Green Roof--FBC and MBPs

Caitlin Cameron <ccameron@portlandmaine.gov>

Wed, Mar 30, 2016 at 10:52 AM

DETAILS - ROOF

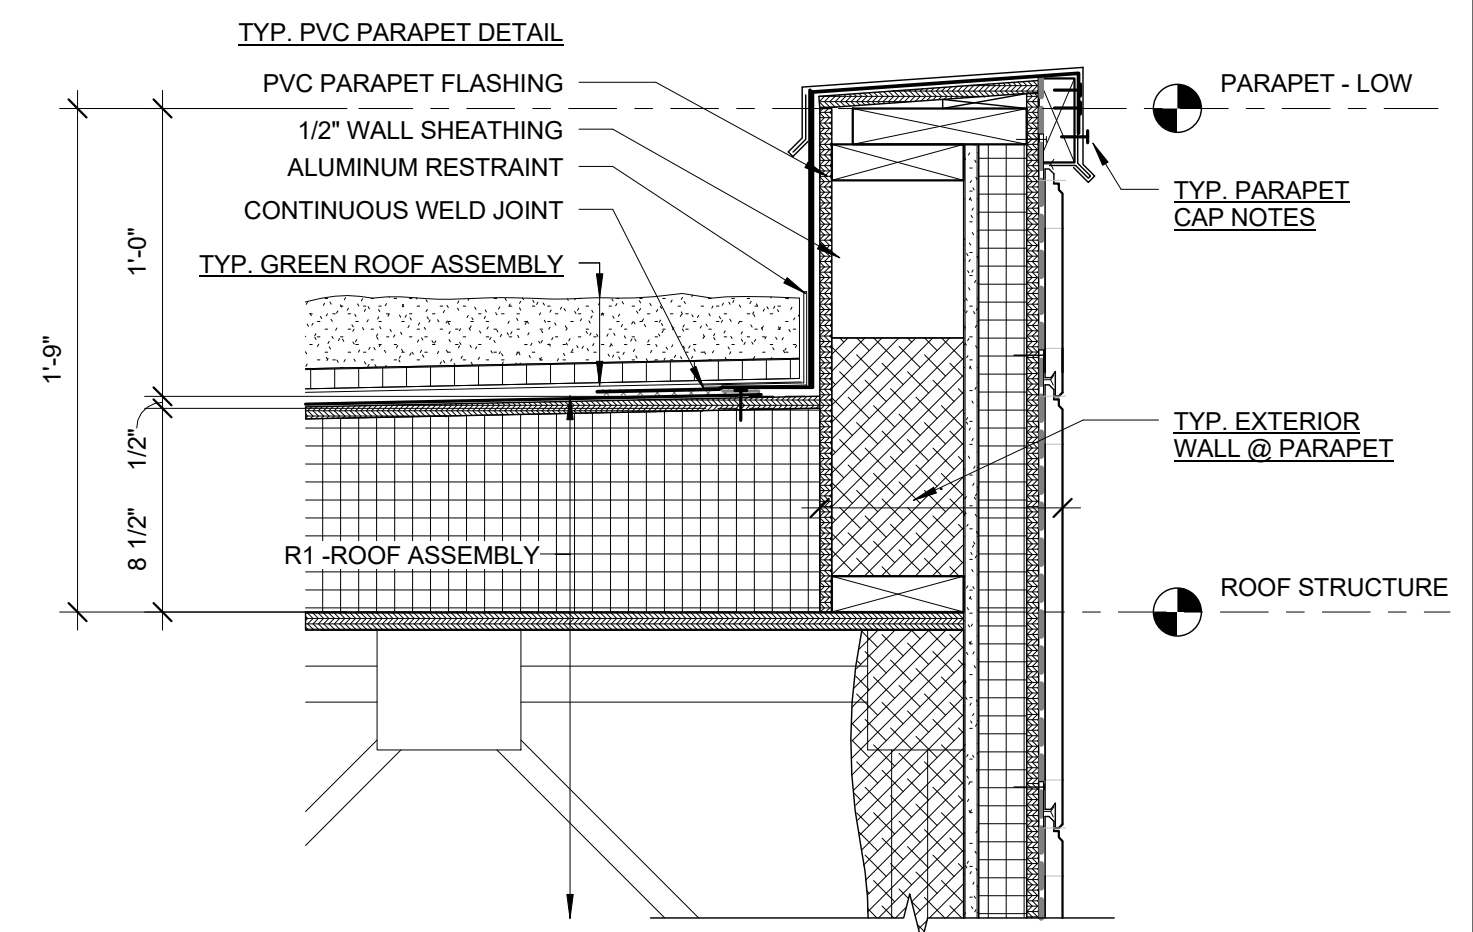
- 1) Provide a roof plan (drainageways, flow direction, for example)
- 2) Details, designs, and specifications - specifically, Dave is missing construction details
- 3) Provide an Inspection and Management Plan with list of measures, inspection and maintenance tasks, task frequency, responsible parties, housekeeping, and removal and disposal of accumulated sediments in the structure and for the rehabilitation of clogged surface linings. *Appendix B. Inspection and maintenance* and *Appendix C Housekeeping* lists the standards and kinds of tasks looked for in an inspection and management plan.
- 4) Provide the stormwater runoff calculations per Chapter 500 for a 24 hour storm event (water volume, buffer sizing)
